Goodman
Level 17
60 Castlereagh Street
SYDNEY NSW 2000

3 February 2016

**Re: Orica Southlands Industrial Estate Project Approval 060191
Review of Turning Head Hydraulic Modelling Assessment**

Figure 6: 10% AEP Design and Turning Head Scenario 1 differences to Existing

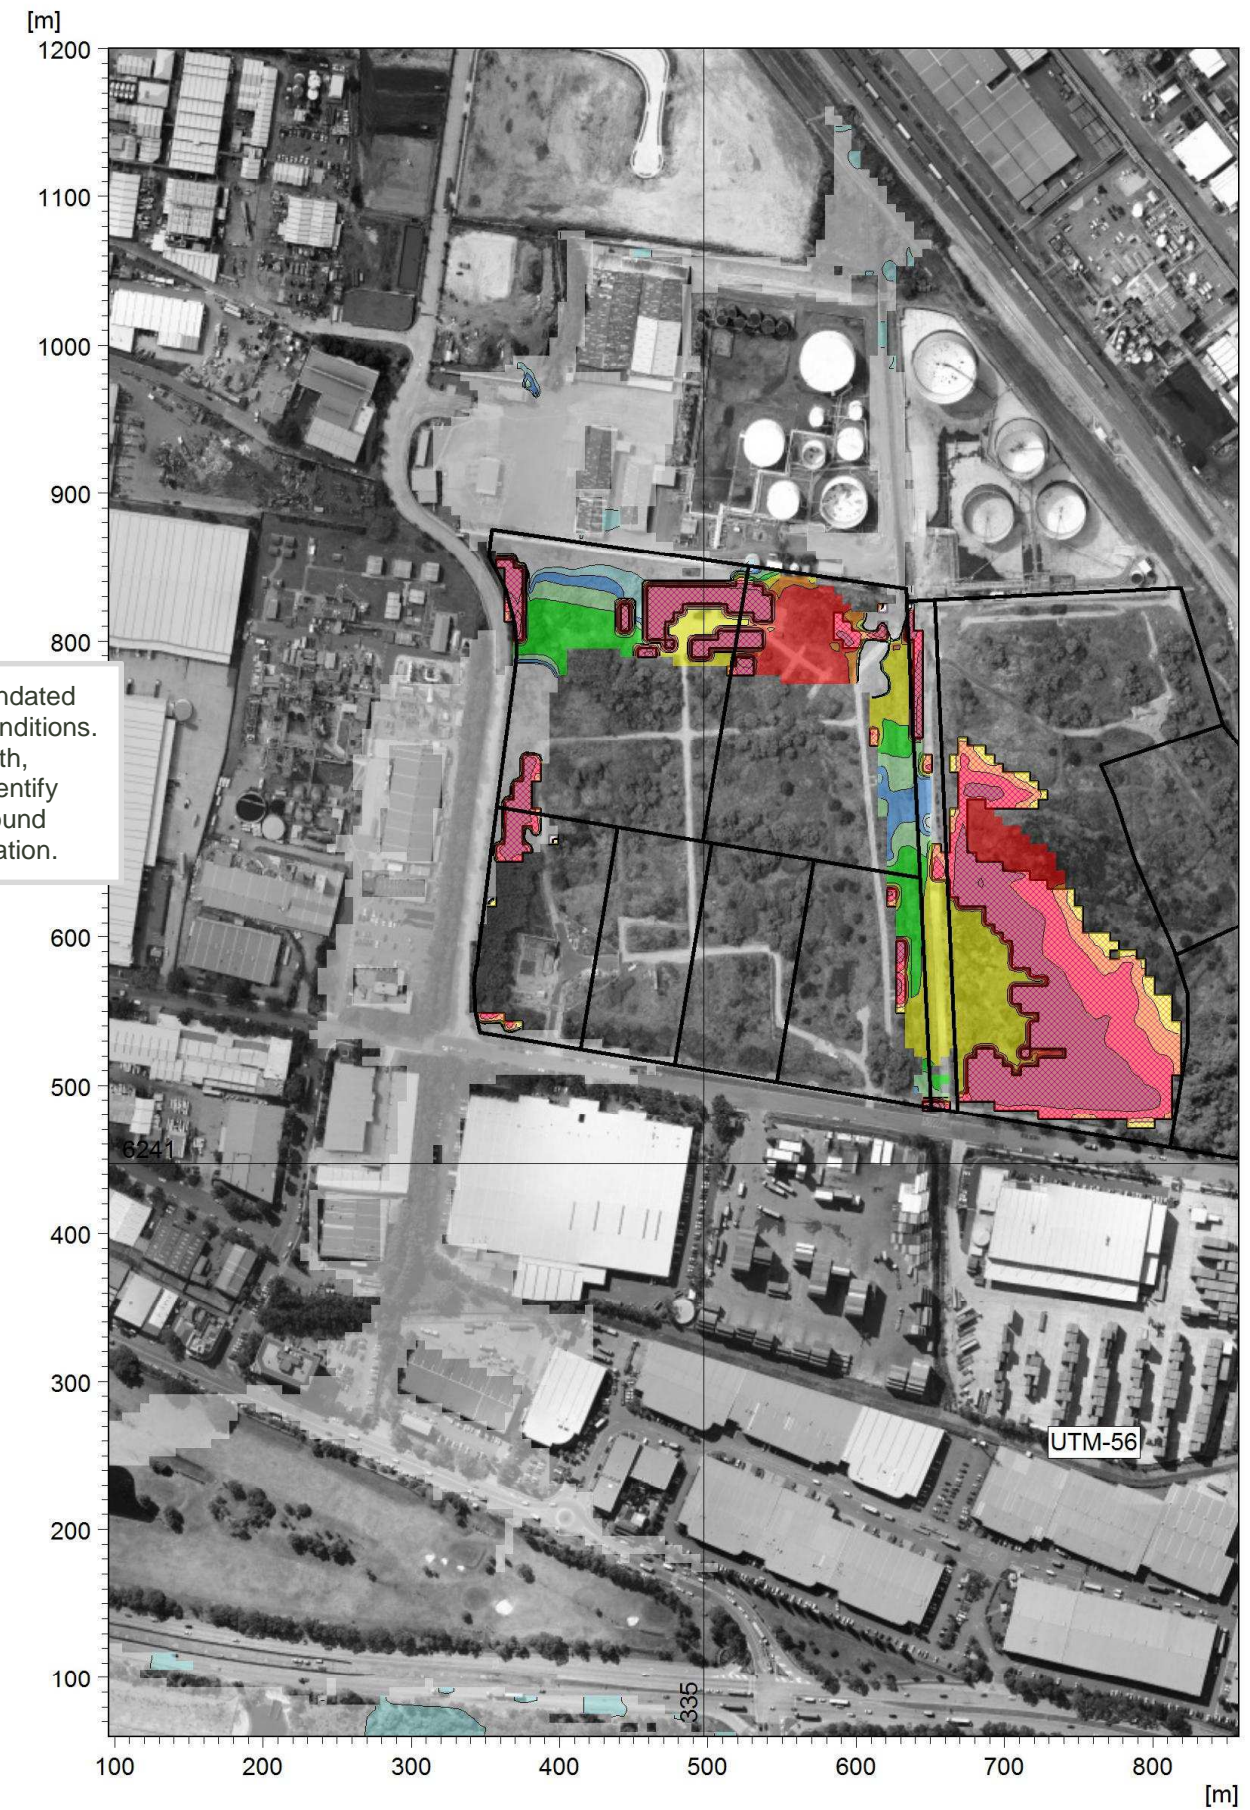
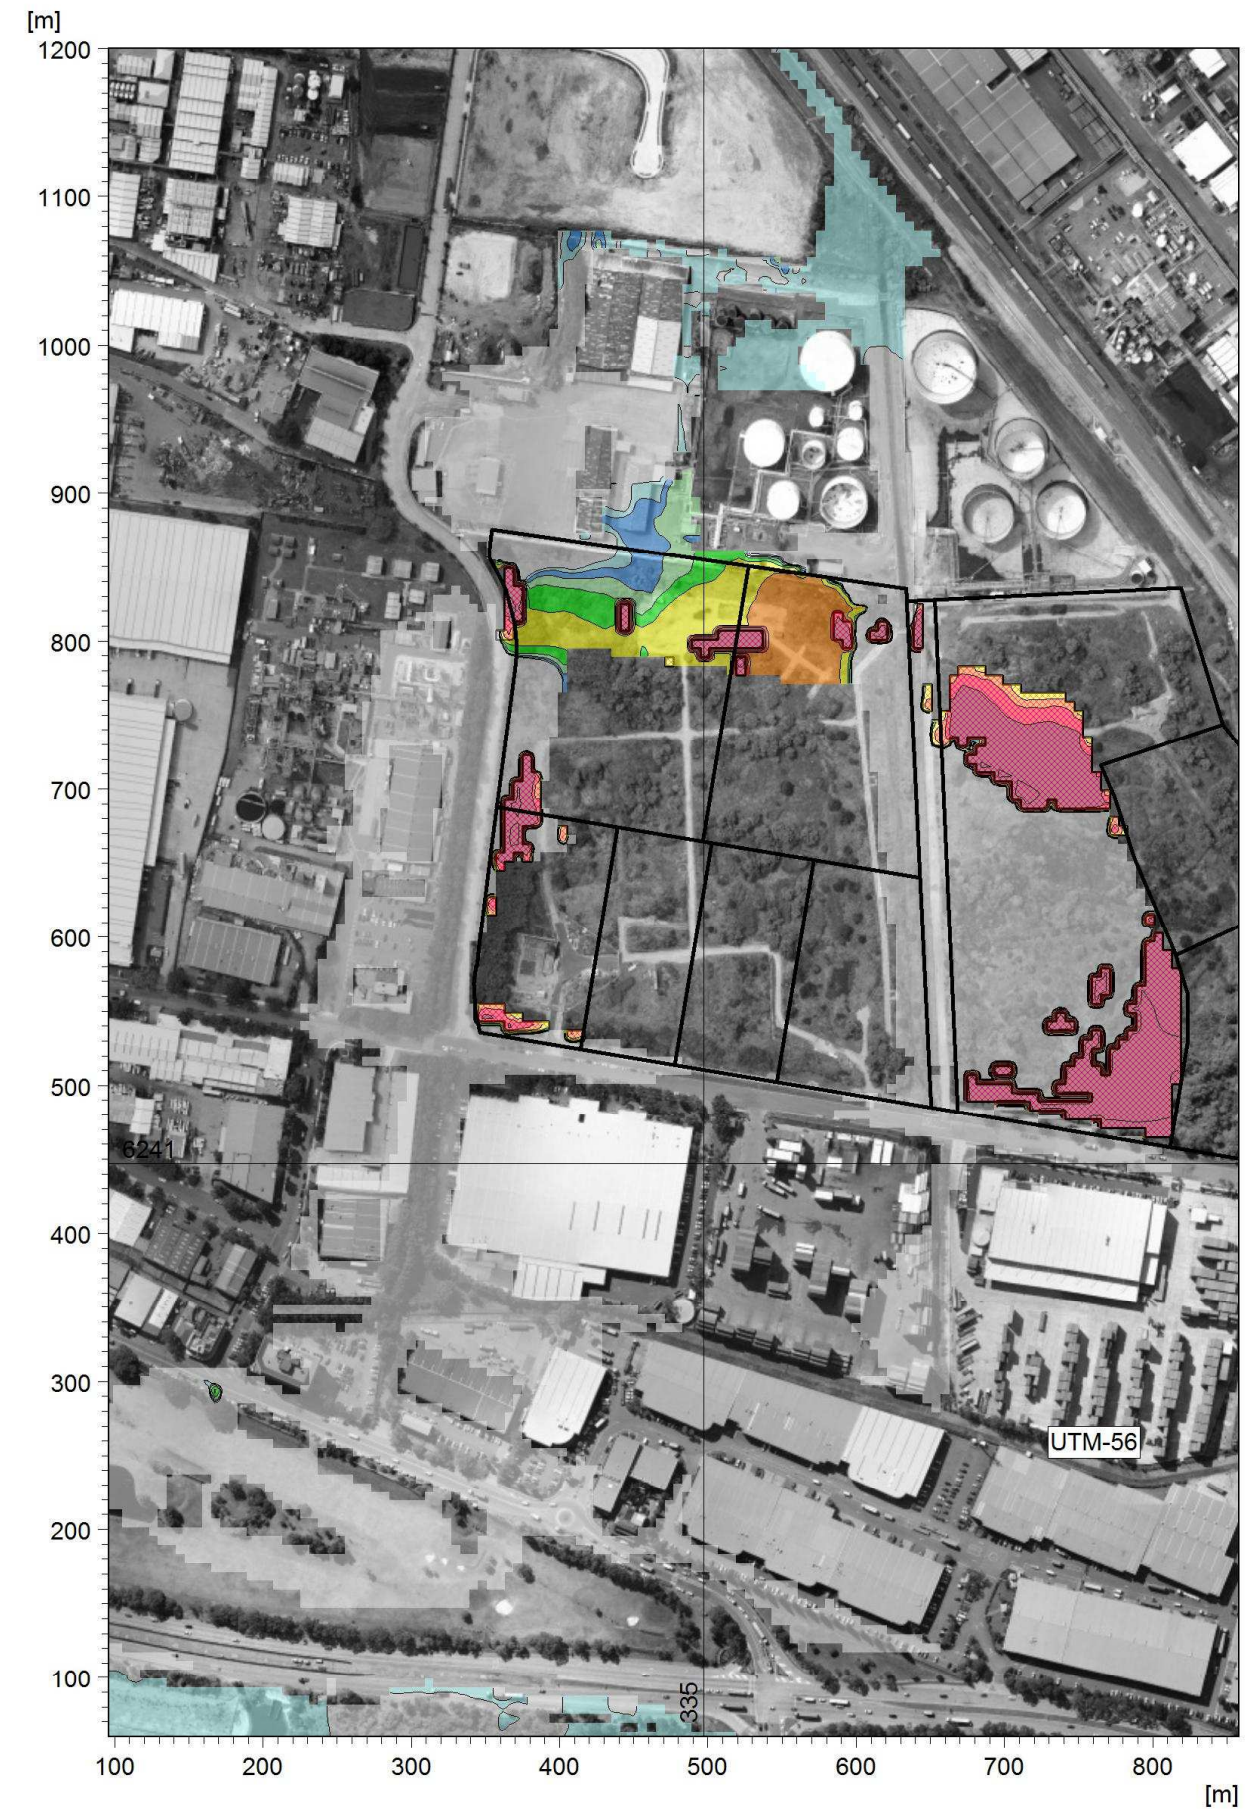
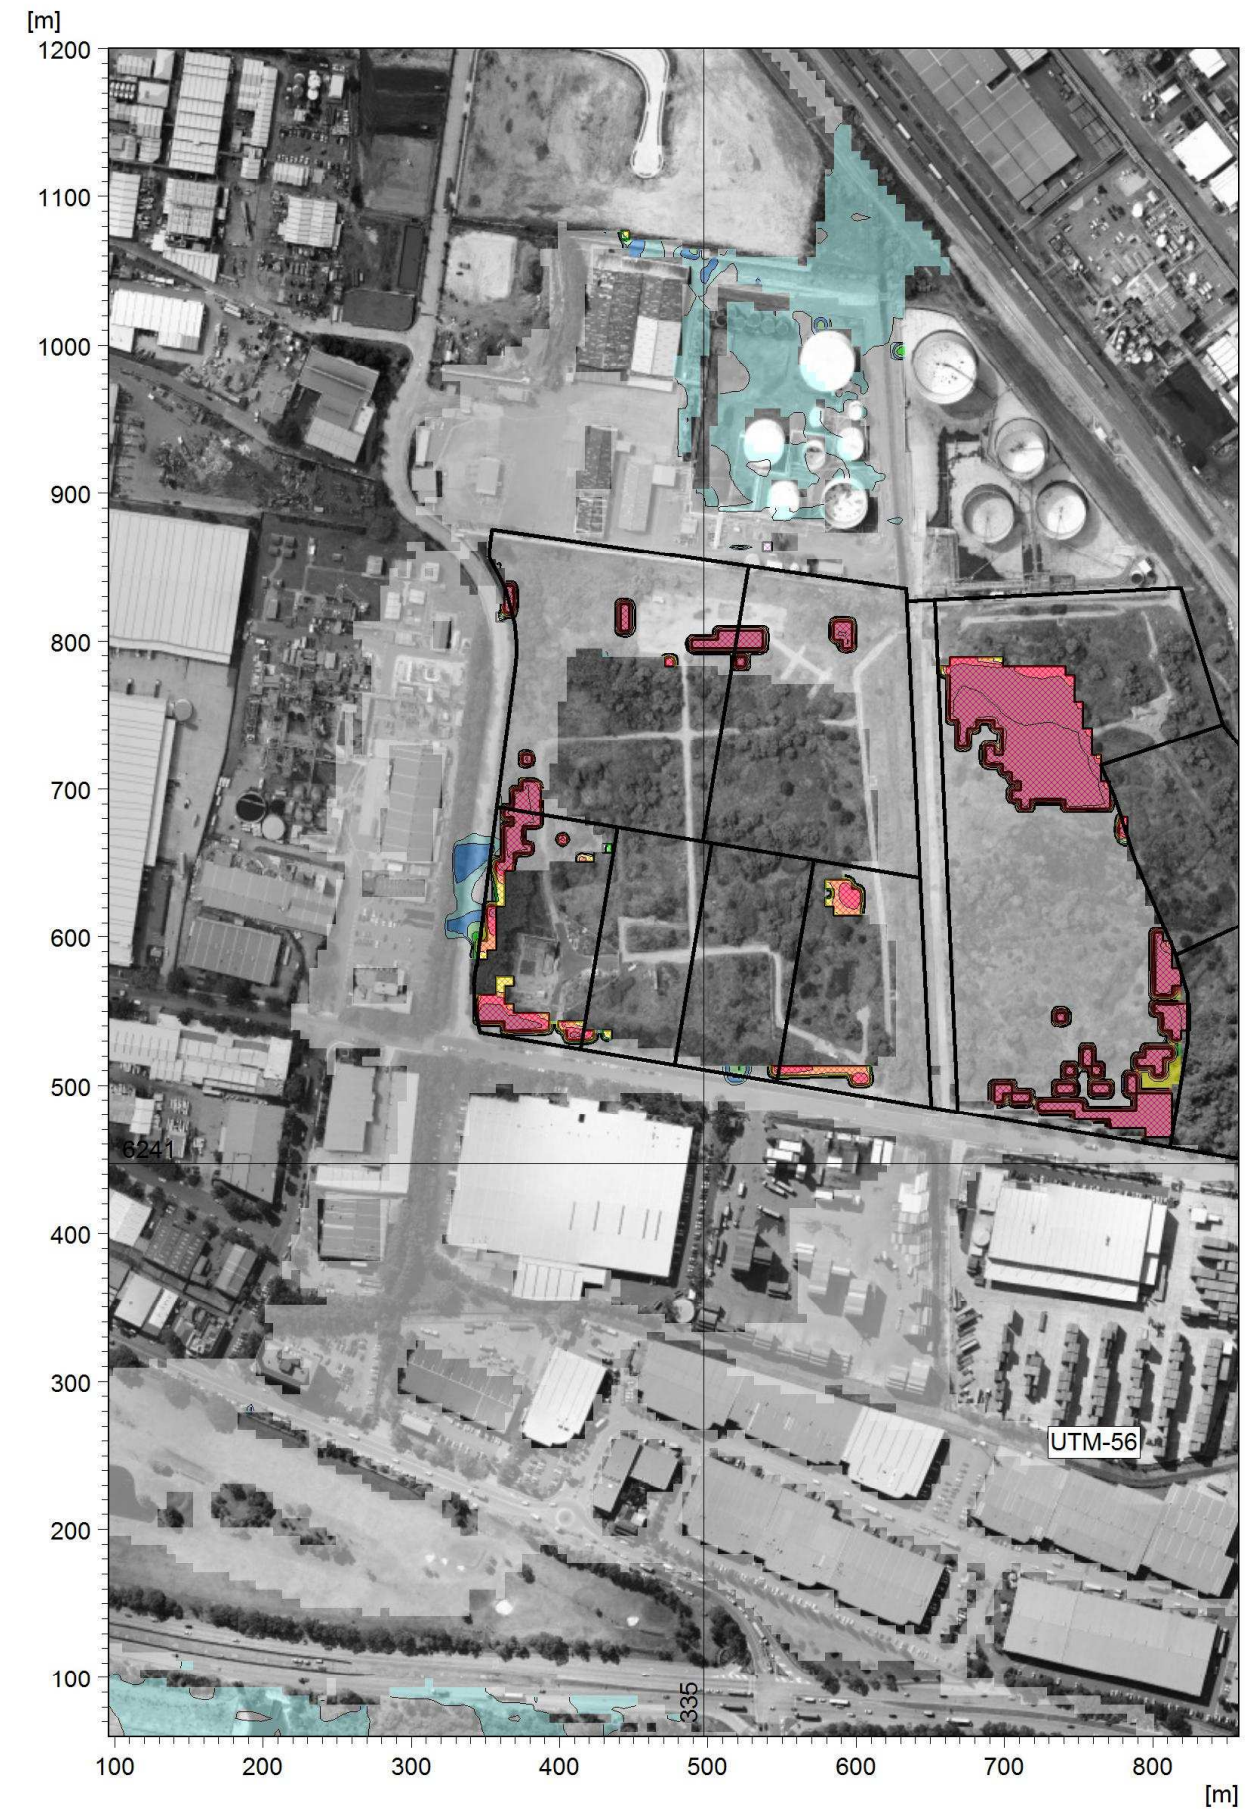
Yes. A summary of our review is as follows.

- Changes in flood impacts within the subject site itself can be ignored. These have occurred due to modifications to the earthworks from the design and by themselves only affect the site owners;
- The small changes in flood level above those already approved are within the tolerance of the construction methods, survey and hydraulic modelling and can be ignored;
- The isolated increases in flood impact typically occur in all flood impact assessments using computer models. These are termed numerical instabilities and are not reflective of the general impacts in the local area. For this reason they can be ignored.

Yes, taking into account the above comments, the “as constructed plus turning head” flood impacts are no greater than the nominated design flood impacts and Schedule 3 Condition 10 has been satisfied. Field survey of the constructed turning head should be undertaken and provided to satisfy Condition 10 c).
